Application for a non-material amendment following a grant of planning permission. Town and Country Planning Act 1990

Unit:		House number: 3	House suffix:	
House name:				
Address 1:	MEZEN CLOSE			
Address 2:				
Address 3:				
Town:	NORTHWOOD			
County:	MIDDLESEX			
Postcode (optional):	HA6 2DP			
Description of location or a grid reference. (must be completed if postcode is not known):				
Easting:		Northing:		
Description:

SINGLE STOREY REAR EXTENSION INCLUDING
DEMOLITION OF EXISTING CONSERVATORY

73 094 / APP/2020/700

FRONT ELEVATION

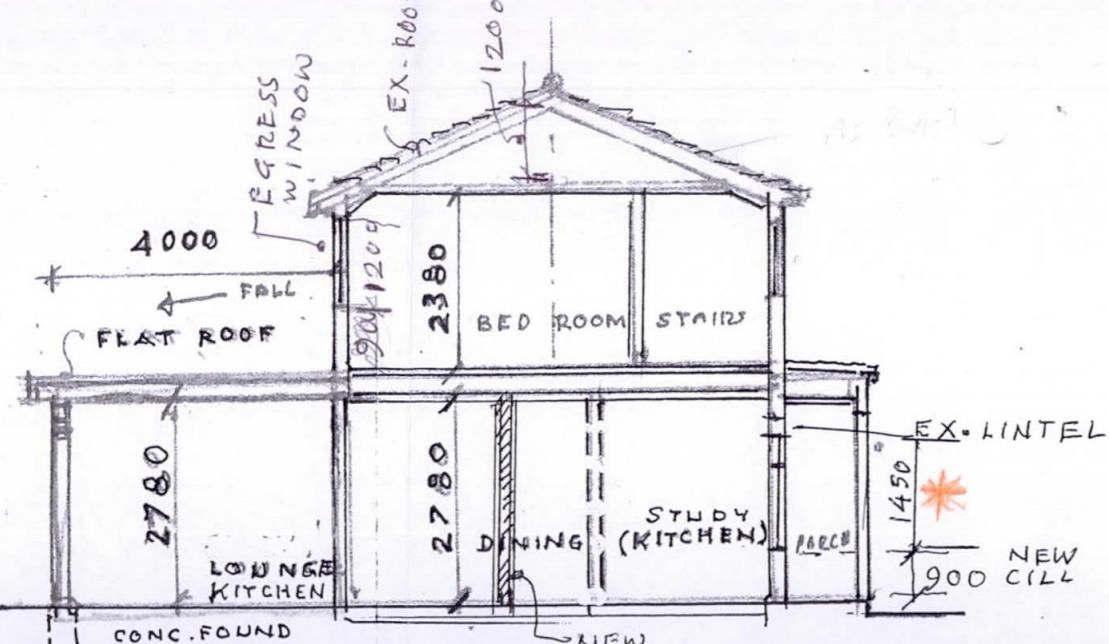
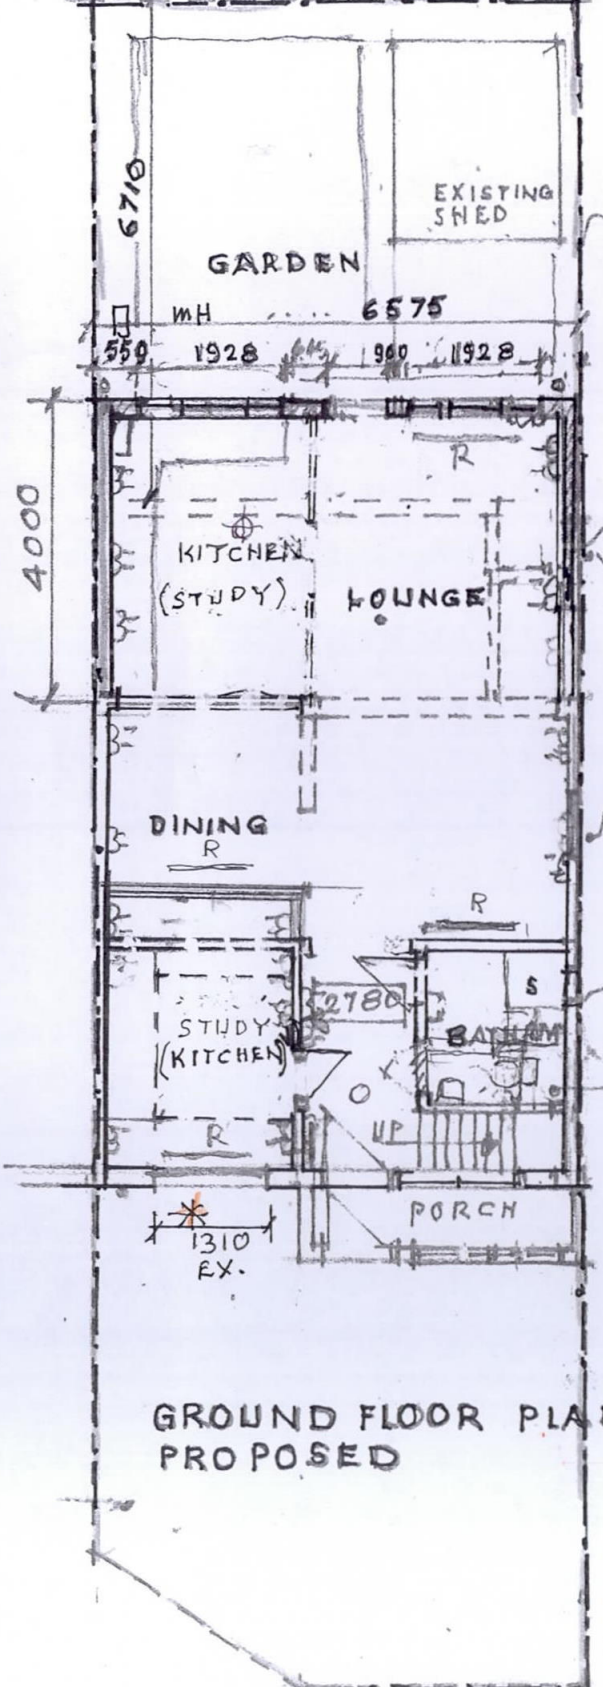
STUDY
HEIGHT OF WINDOW TO ^{STUDY} (KITCHEN) TO BE INCREASED
FROM 1950 mm TO 2450 mm WITH SILL LEVEL = 900 mm.
THE EXISTING WINDOW OPENING WILL REMAIN AS EXISTING.
THE MATERIAL = ALUMINIUM - DOUBLE GLAZING.
